# PLANNING AMENDMENT

| <b>SITE ADDRESS DETAILS</b><br>Ravensdale<br>Bens Gate<br>Holbeach<br>Spalding                                 |                                                                                                                                                               |
| <b>CURRENT APPLICATION NO:</b><br>This amendment cannot be considered unless the relevant reference is stated. | H05-0353-24                                                                                                                                                   |

| <b>FULL DESCRIPTION OF DEVELOPMENT OF CURRENT APPLICATION THAT THIS AMENDMENT RELATES TO</b>                                                                                             | Change of use of part of paddock to residential curtilage, extensions and alterations to dwelling including new gated entrance |                   |

TITLE: Gated Entrance - As Proposed

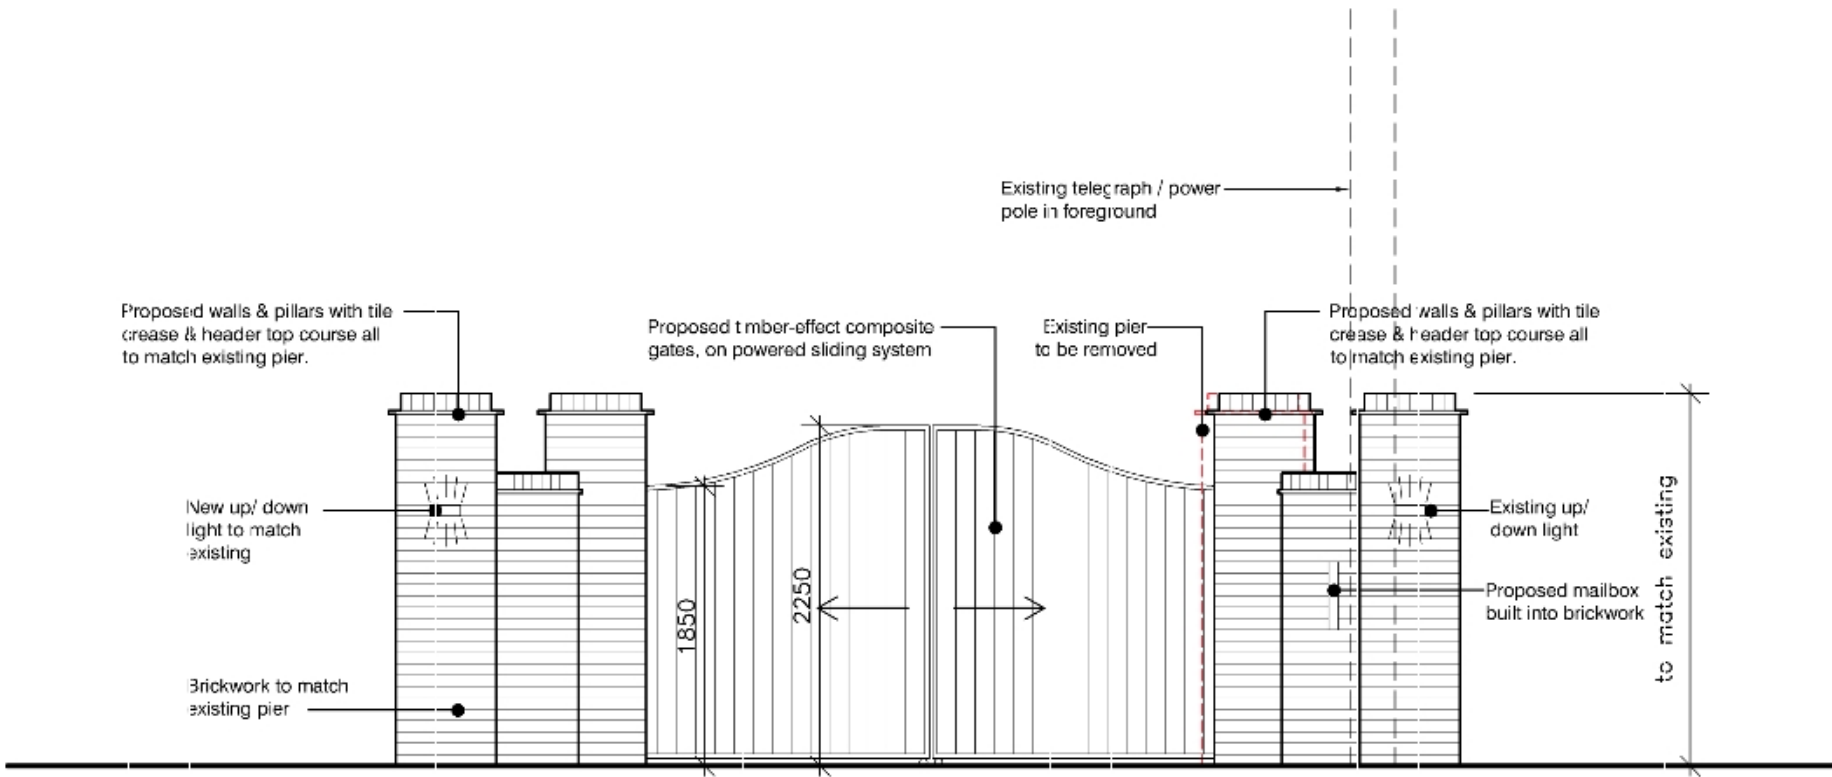
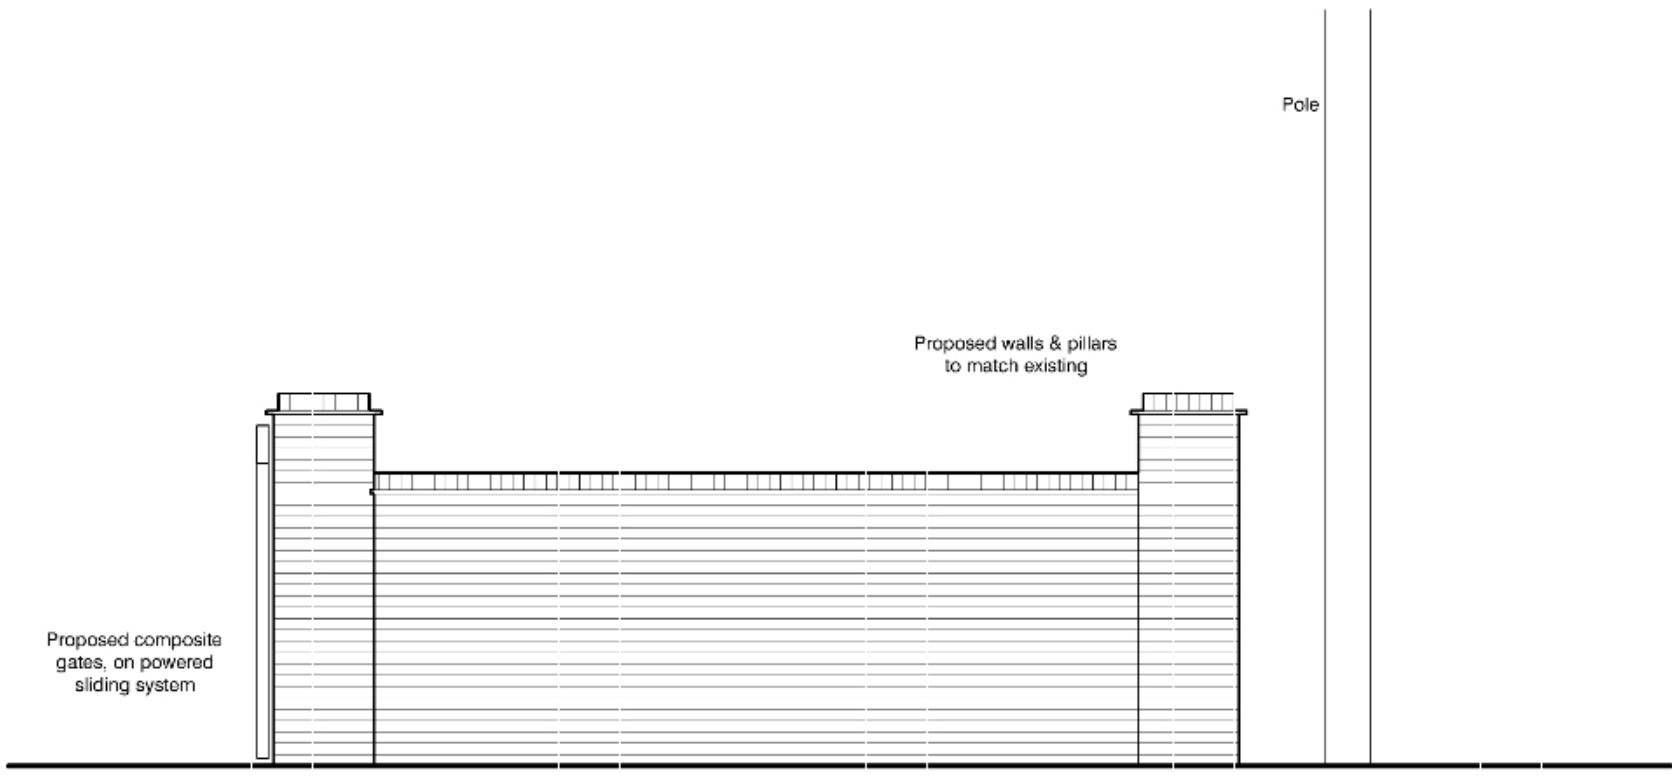
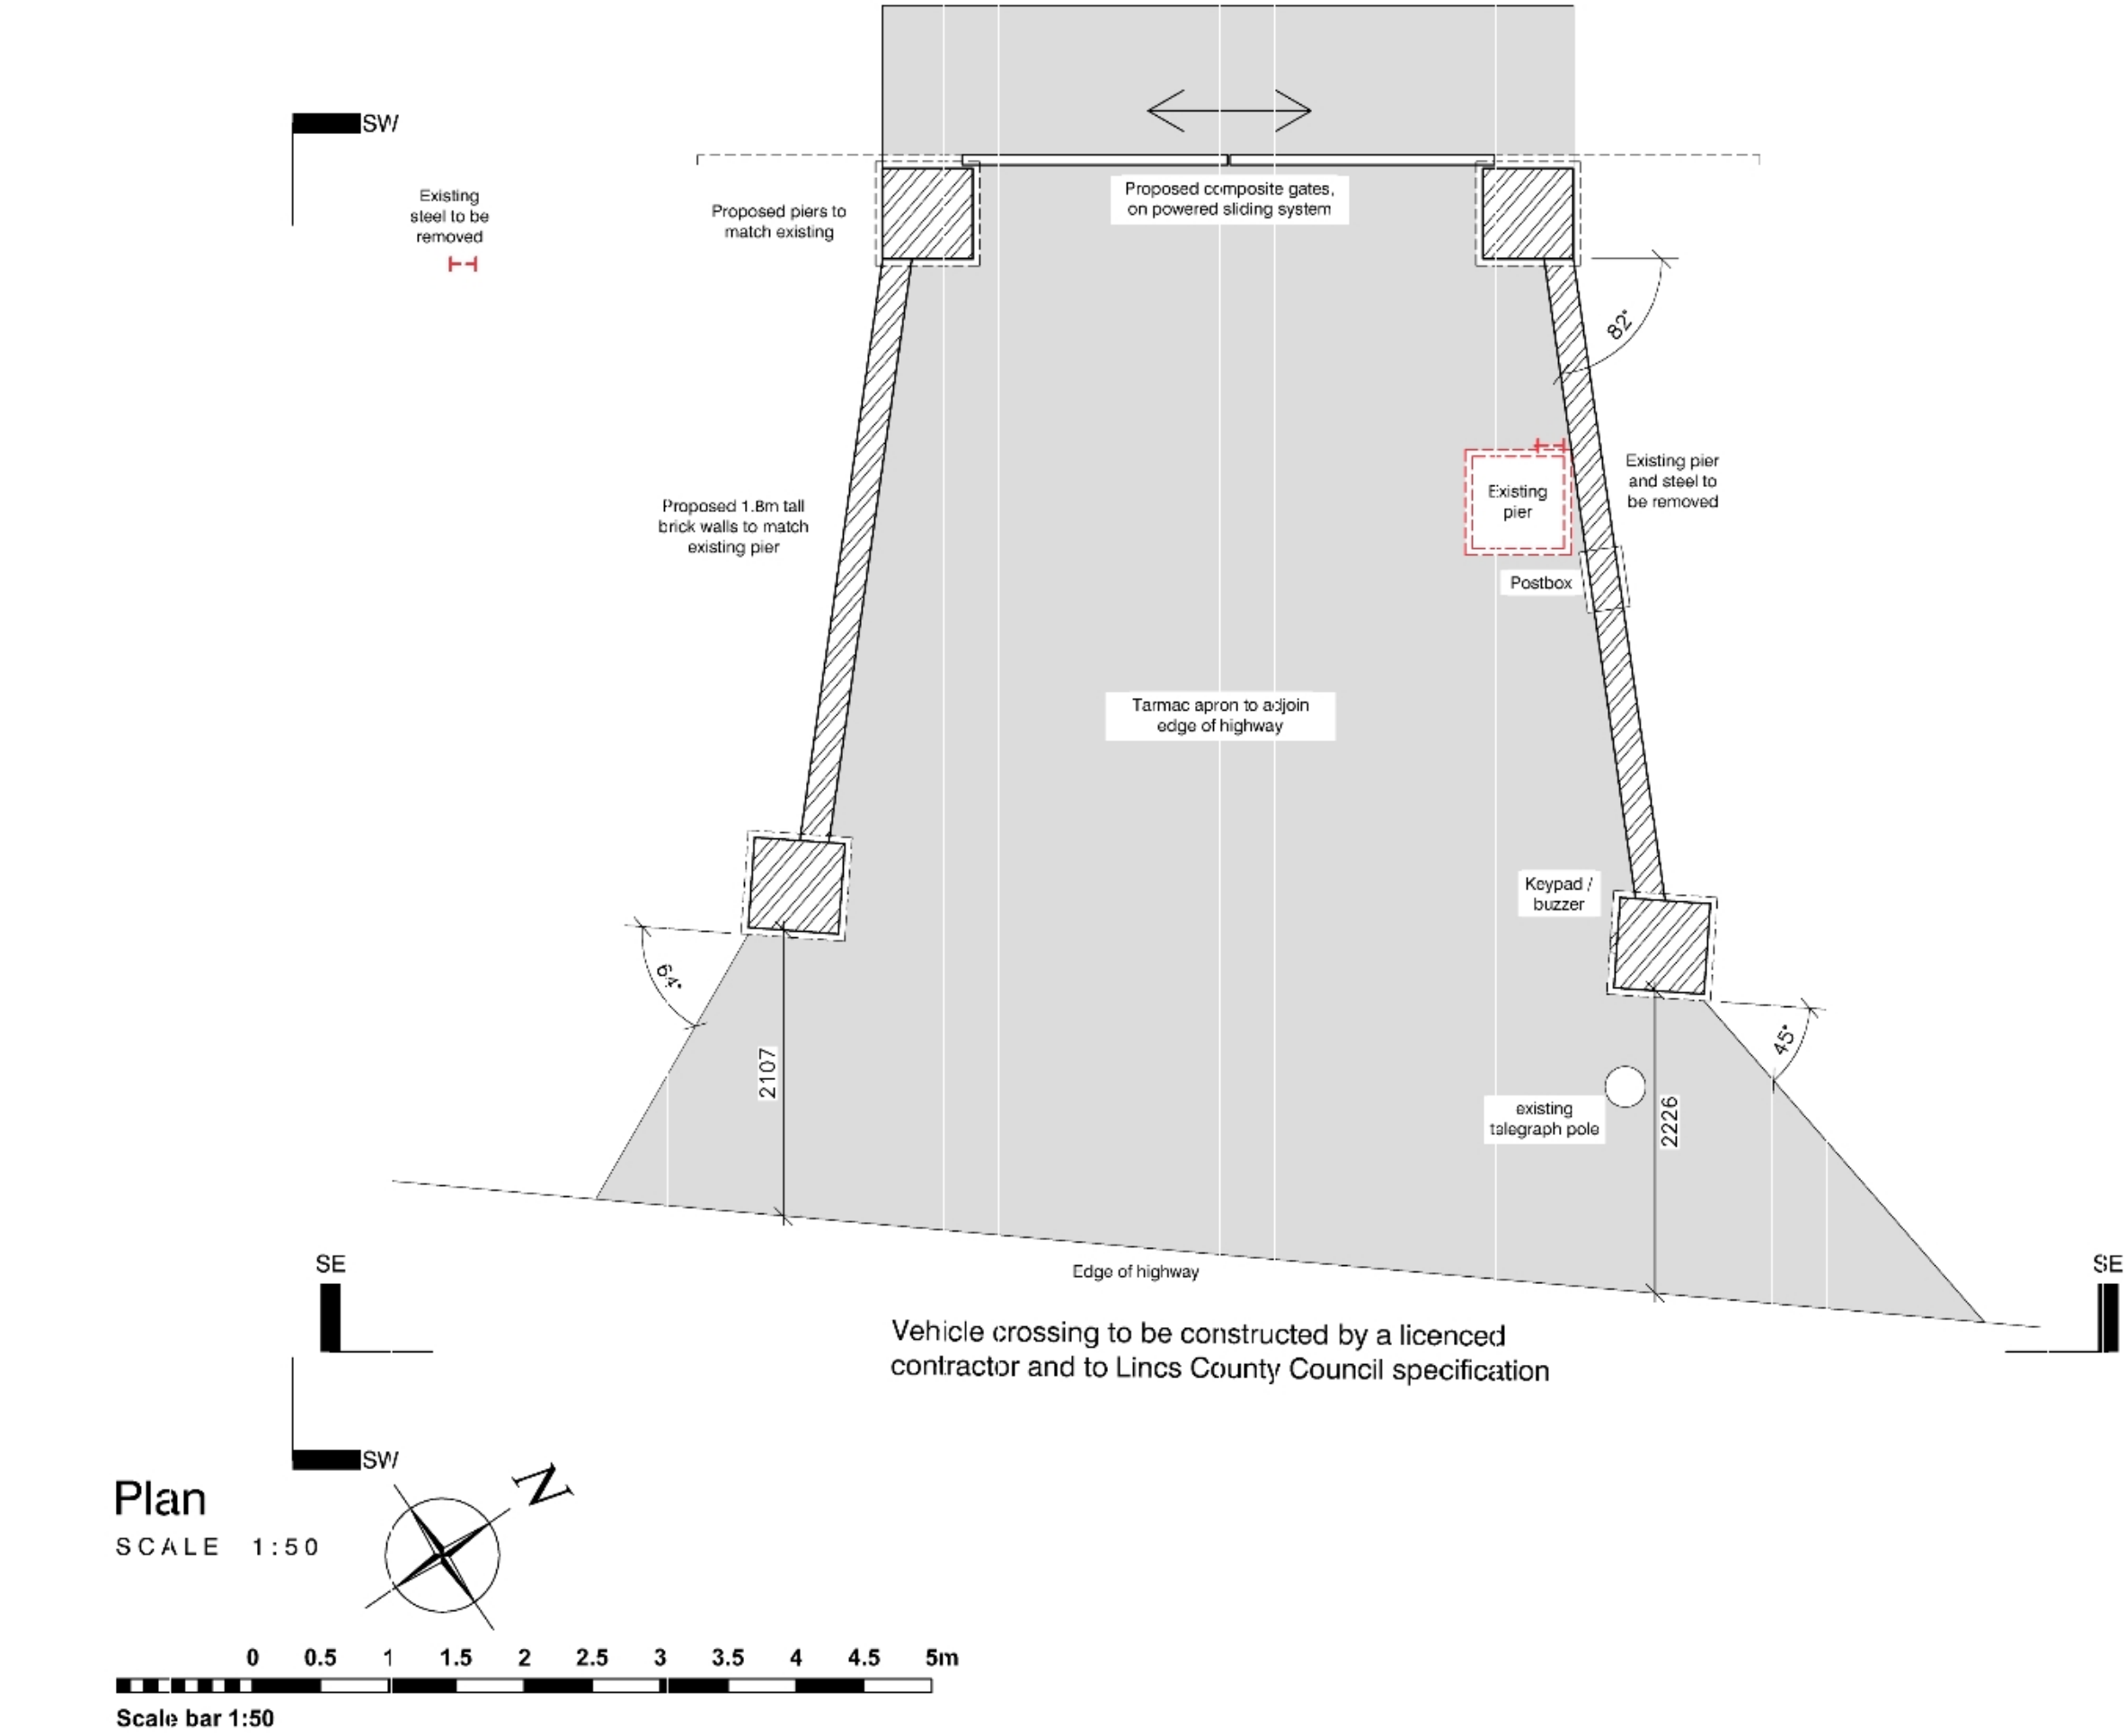
| State details of amendments proposed. (Give a full detailed list of the changes; and also mark these clearly on the accompanying plans. Only the changes listed here will be considered) | Amendment from block paving to tarmac for vehicle crossover as shown                                                           |                   |
